6 December 2012

**Submission on State Significant Development Application SSD 5109 for Cooma
Road Quarry Continued Operations project**

Queanbeyan City Council Submission - Cooma Road Quarry Continued Operations Project

Primary/Secondary Transport Routes

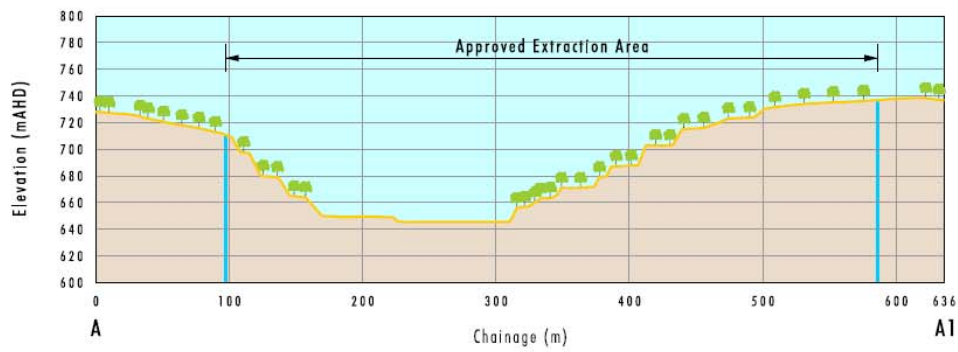
Transport routes should be restricted to those shown on Figure 3, with the exception that the existing Queanbeyan heavy vehicle bypass route via Canberra Avenue, Kendall Avenue North and Uriarra Road should be included to facilitate possible haulage to the Beard (ACT) industrial estate. This will negate use of Crawford Street west of Monaro Street.

- 2.12 Product haulage shall be via routes nominated in Appendix 11 – Traffic Impact Assessment of the EIS together with the Queanbeyan heavy vehicle by-pass route. Delivery to destinations within Queanbeyan LGA shall utilise the approved haulage routes as far as practicable before utilising other streets. The section of Crawford Street from Monaro Street to Morisset Street shall not be used as a transport route.
